From: Paul Cann
Sent: 05 March 2018 15:04
To: Planning.Responses
Subject: RE: Planning Consultation on BE/22/18/DOC

Condition 5 Surface Water Drainage

APPLICATION NO: **BE/22/18/DOC**

Registered: 22-FEB-18
Site Address: Land West of New Barn Lane Bersted

CONNECTION TO HEADWALL FOR DRAINAGE DITCH
SCALE 1:20

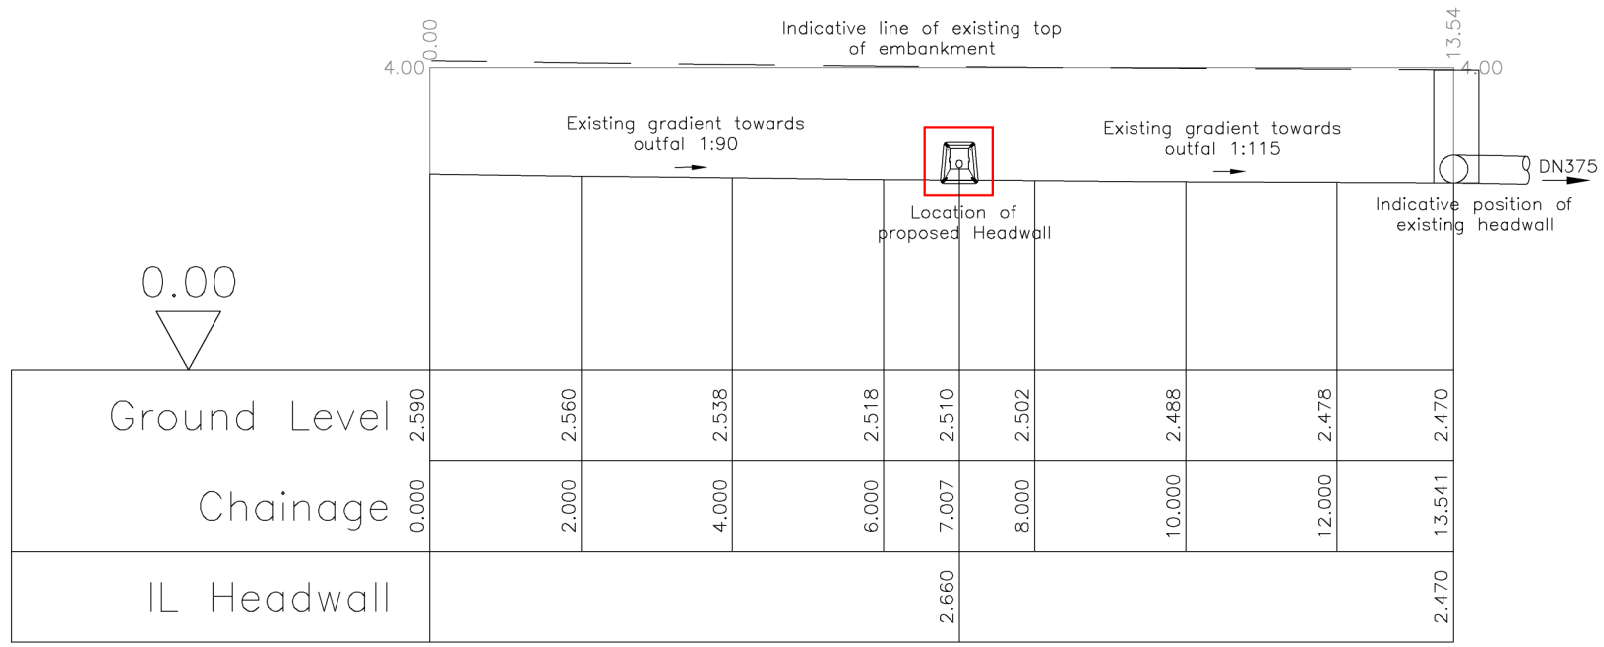
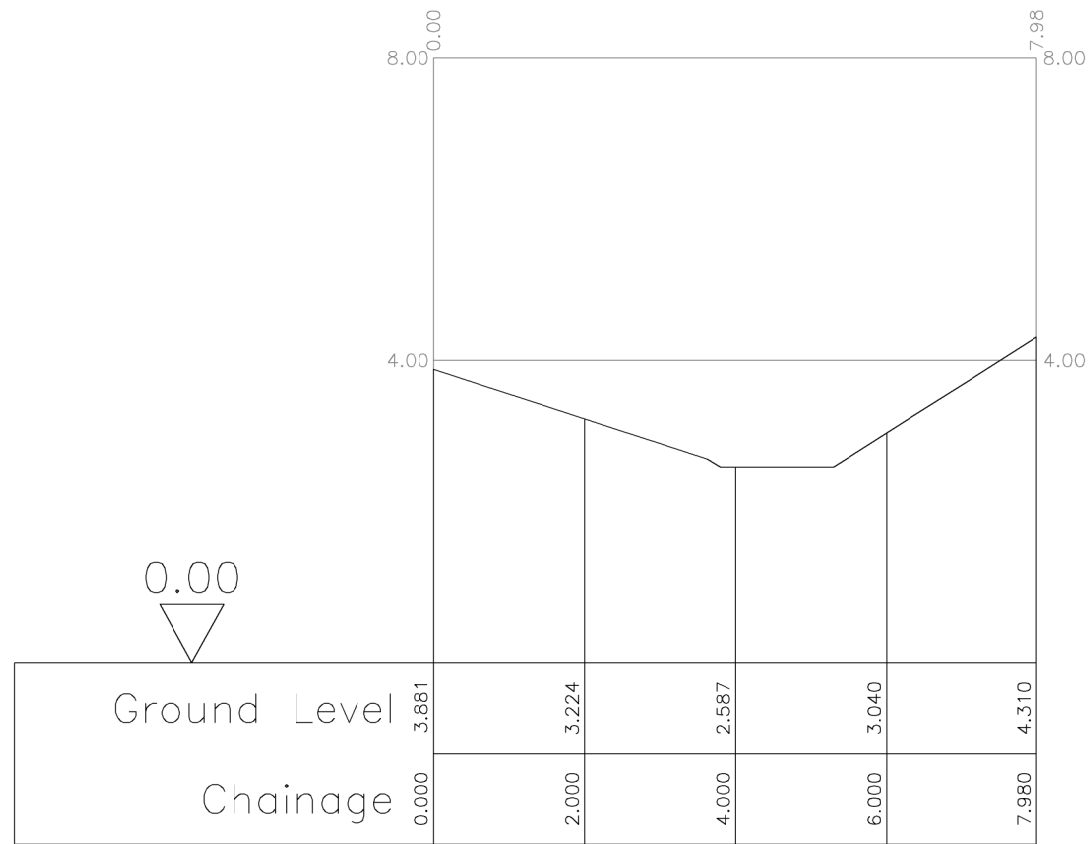
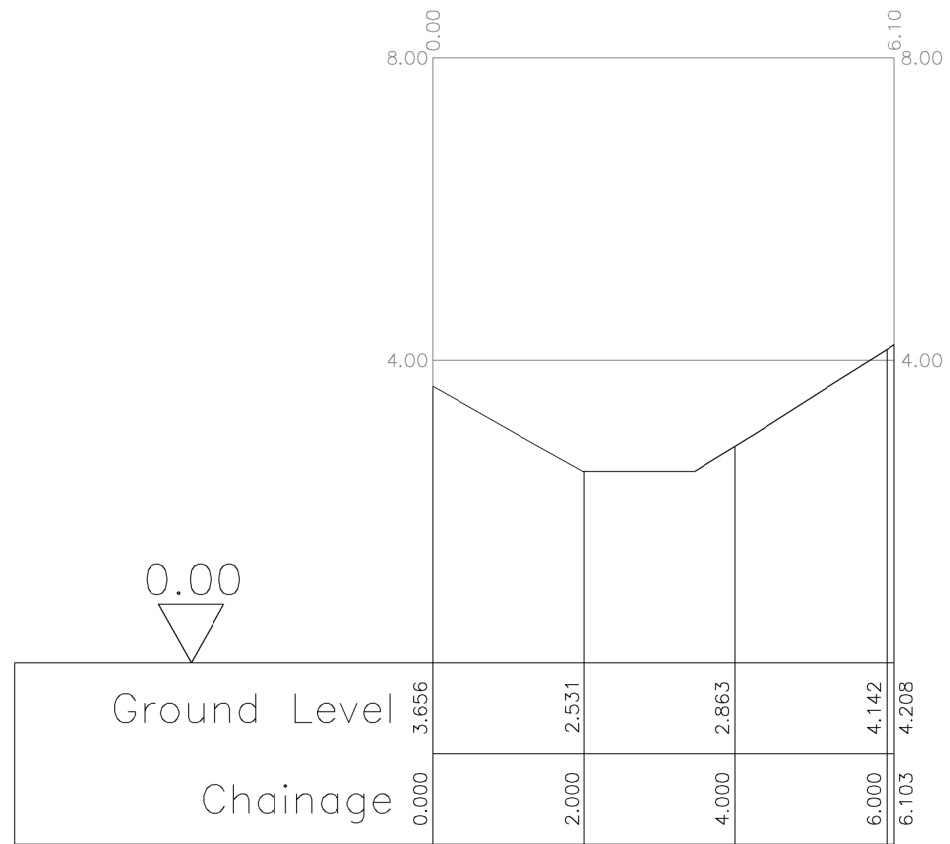
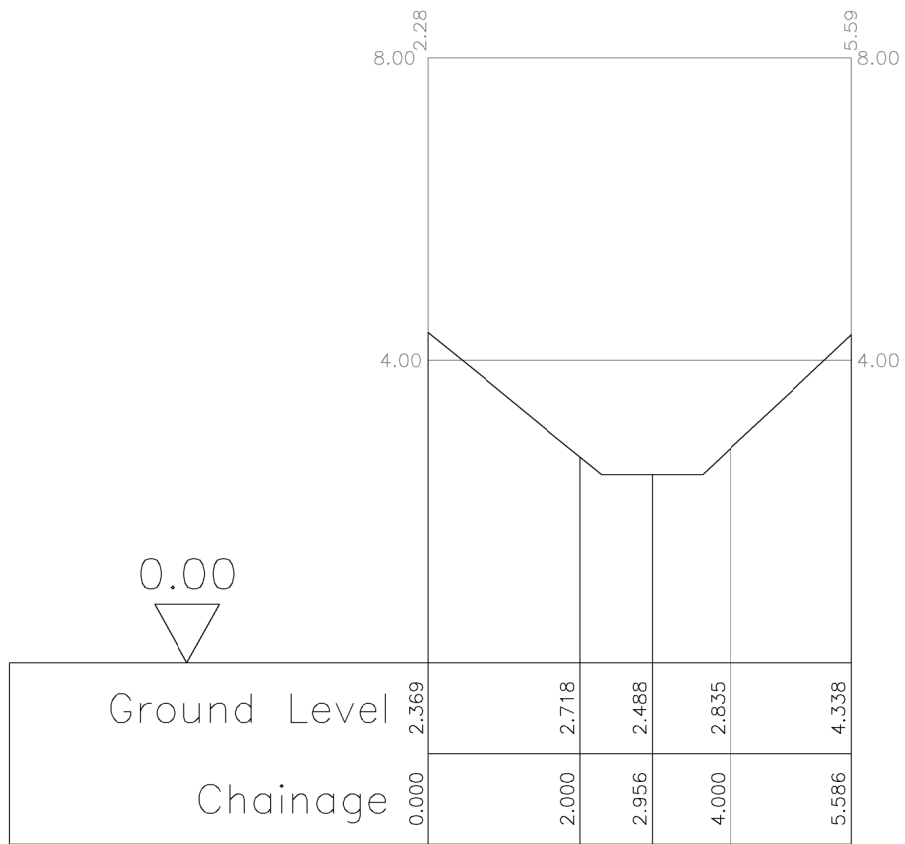
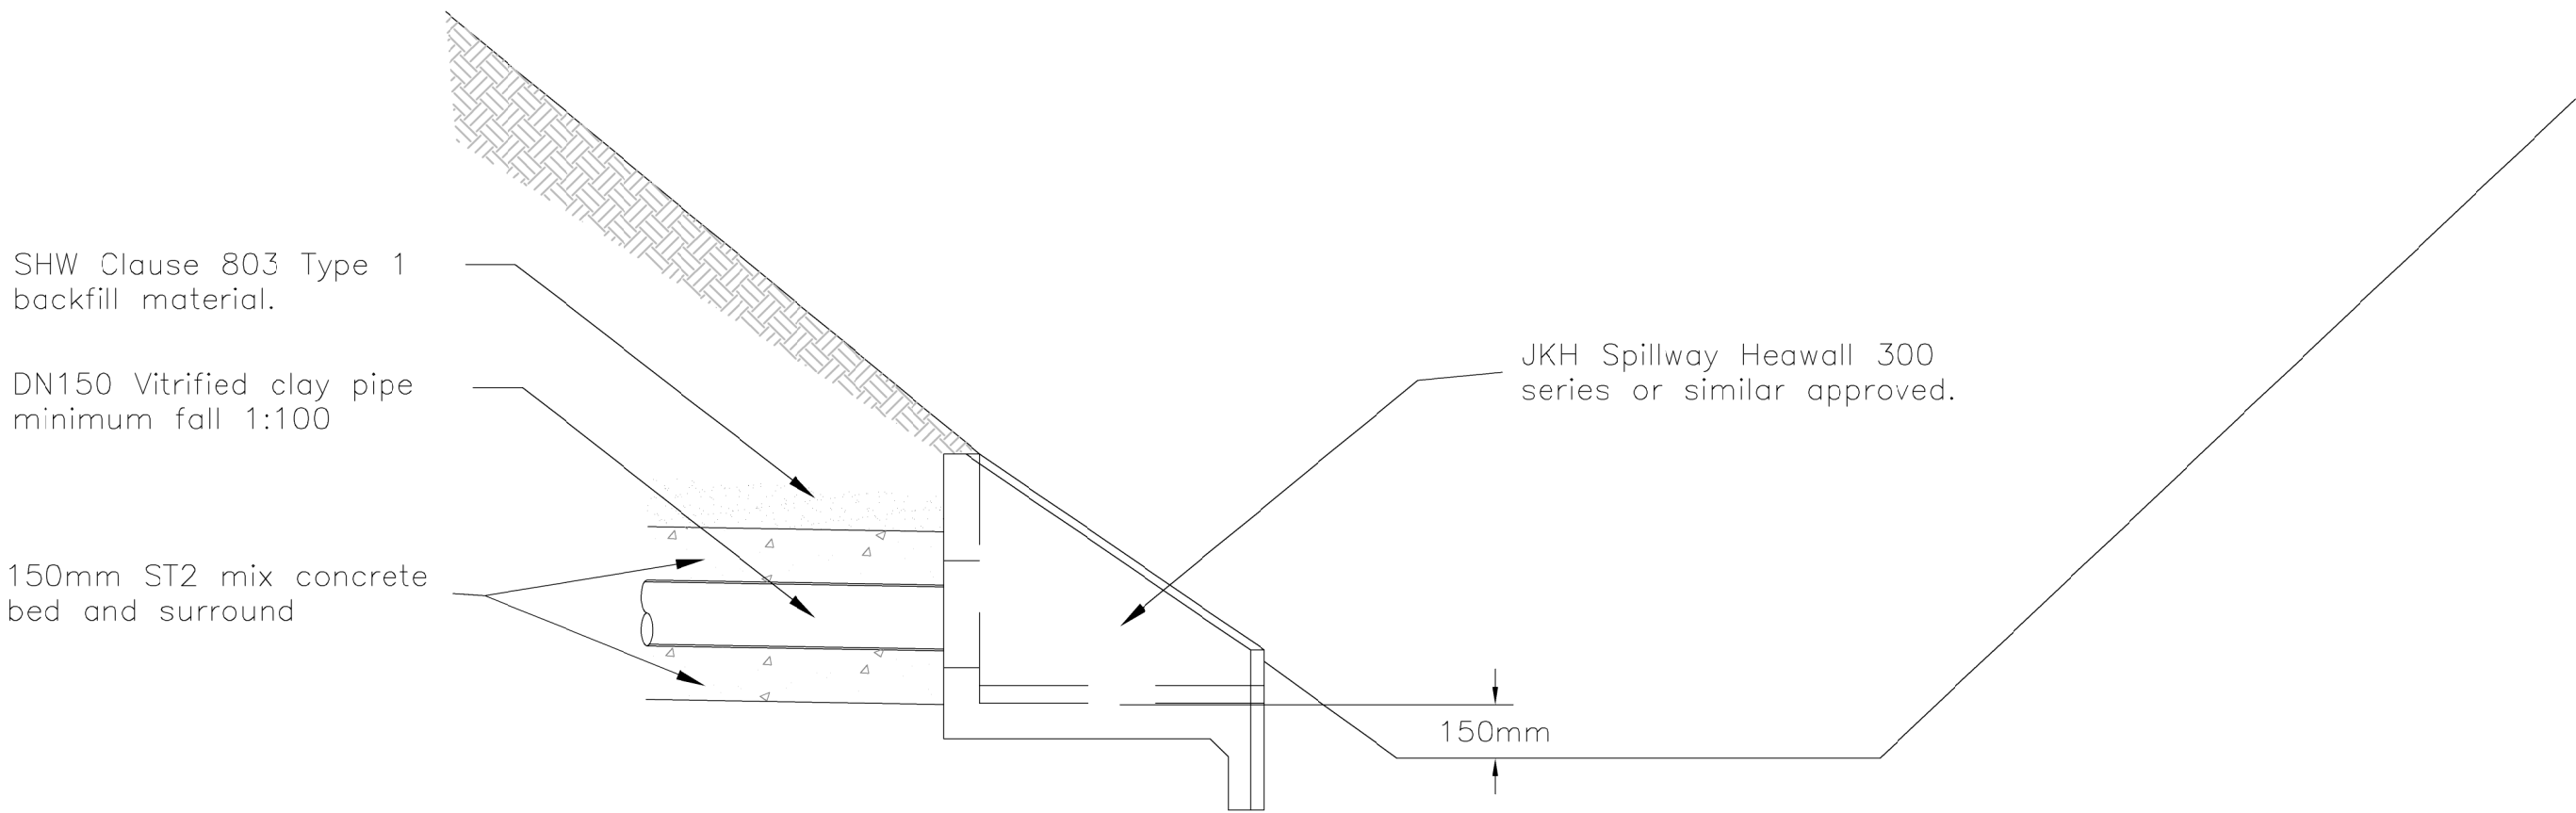
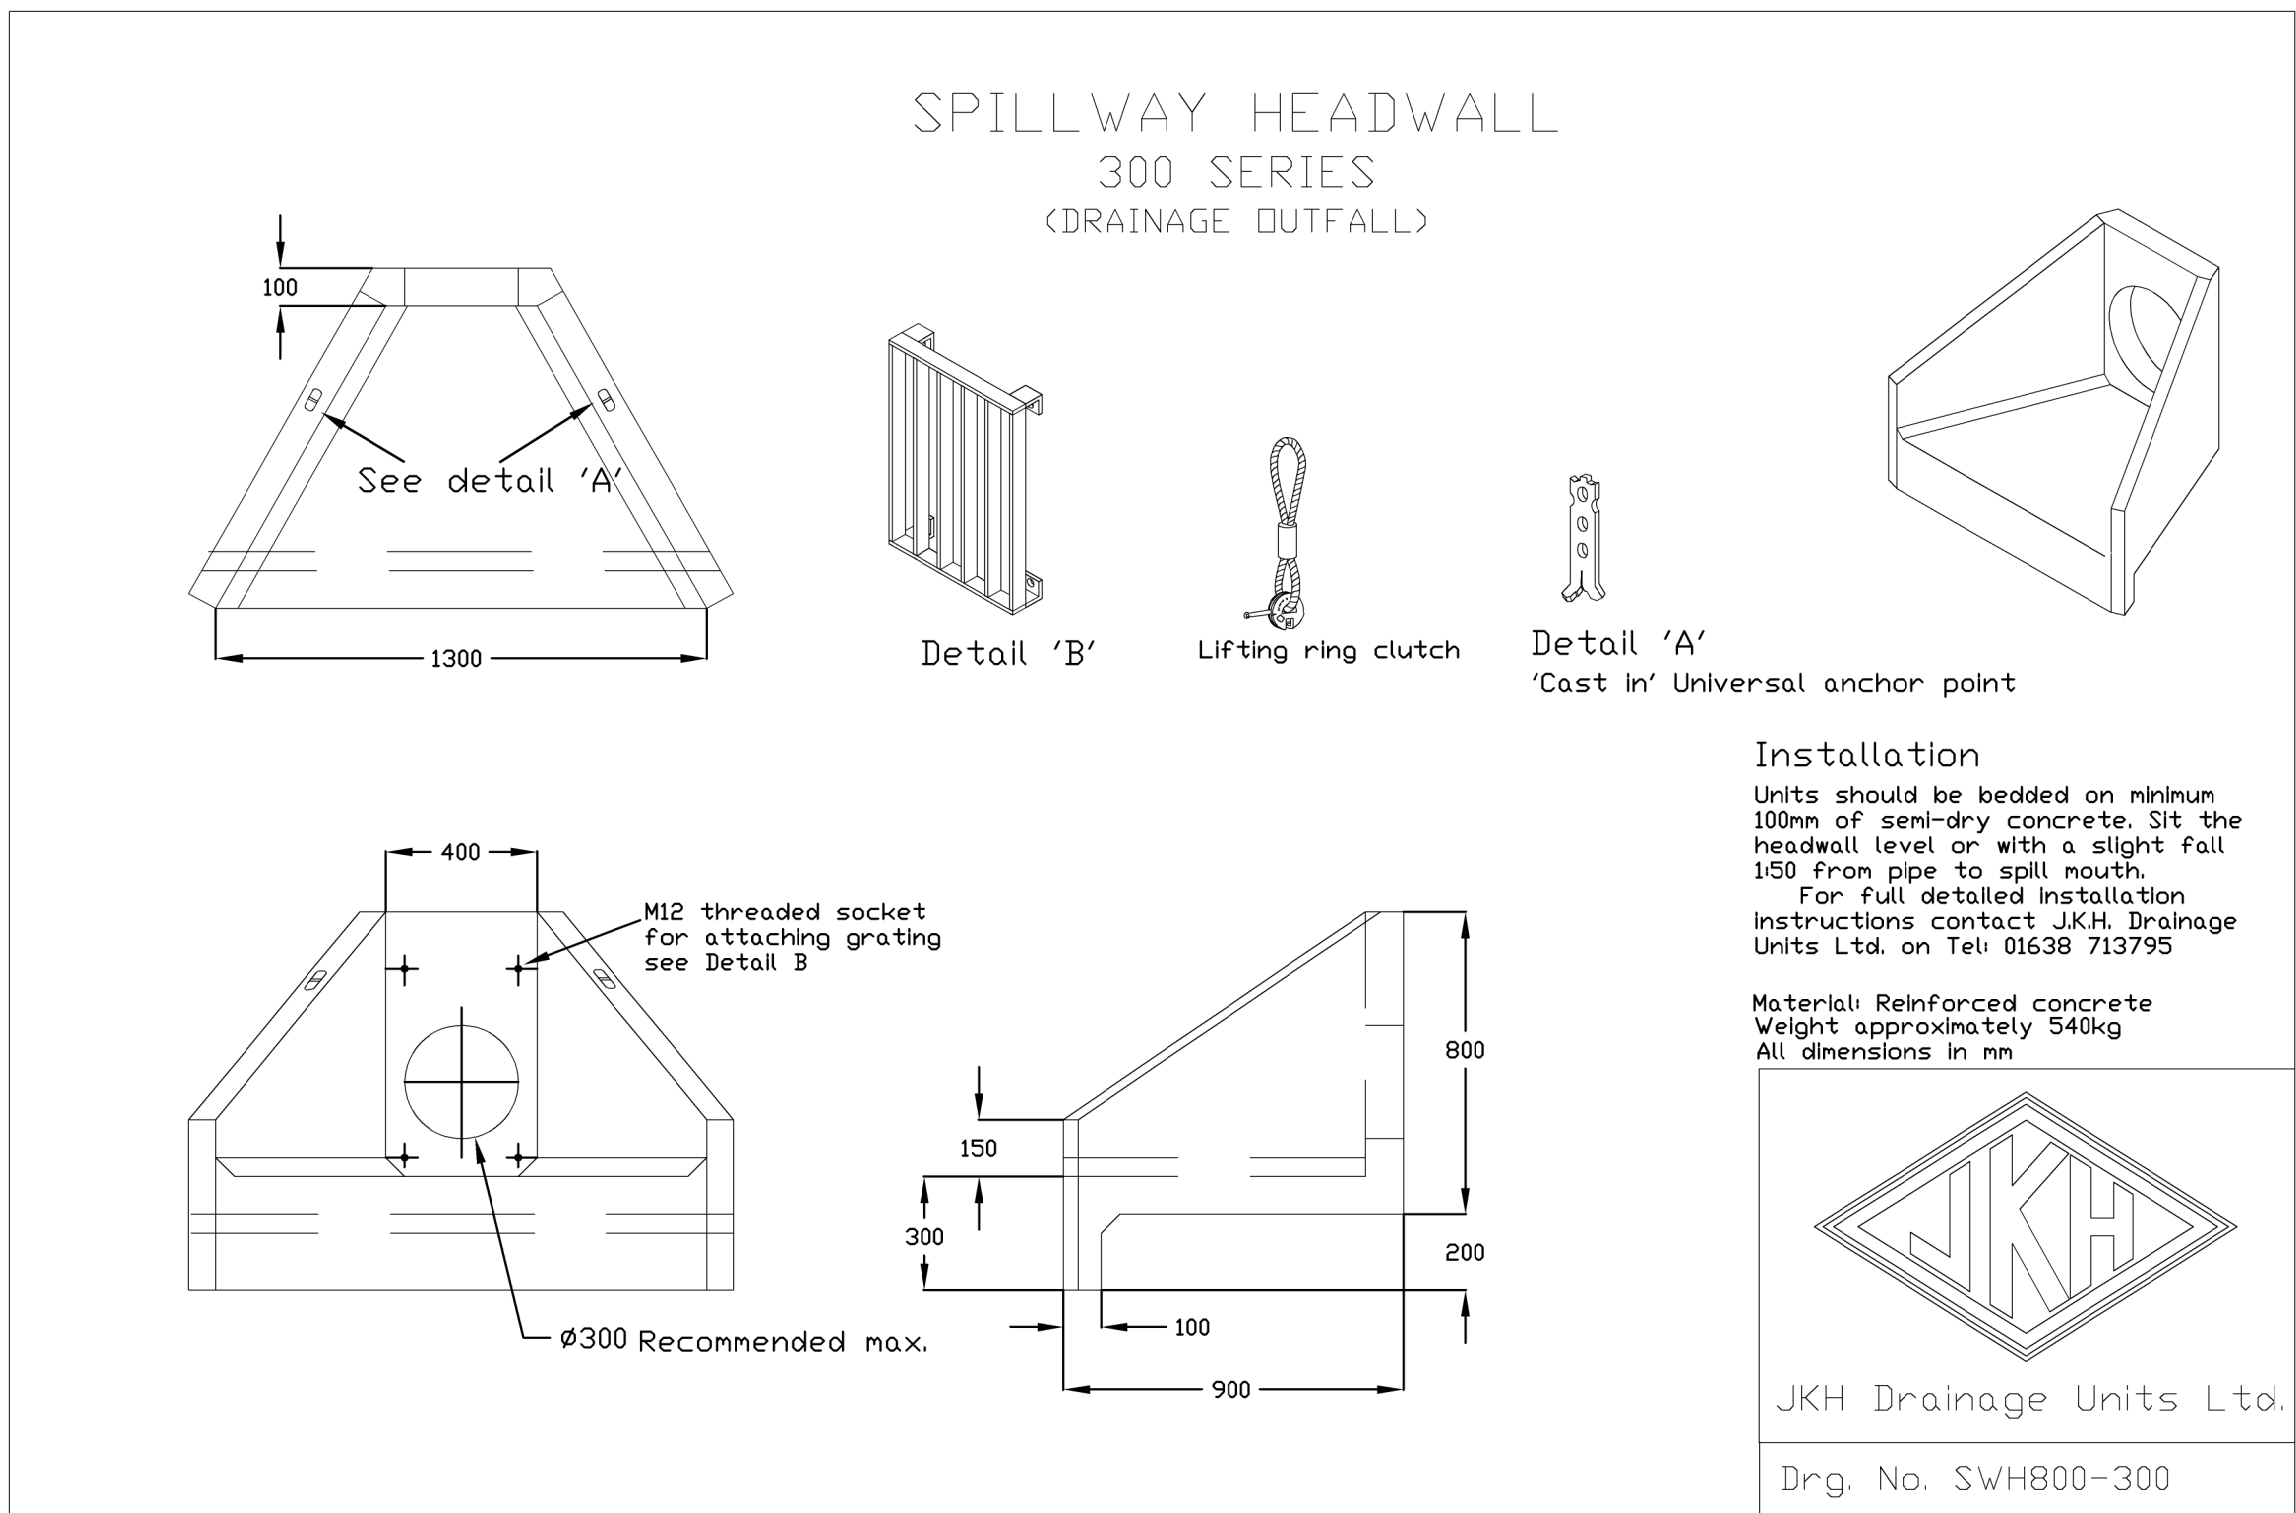
14. Provide headwall details for outfall in NE corner. The structure should not encroach into the ditch profile.
15. Show full pipe details immediately downstream of manhole SW16 on layout plan
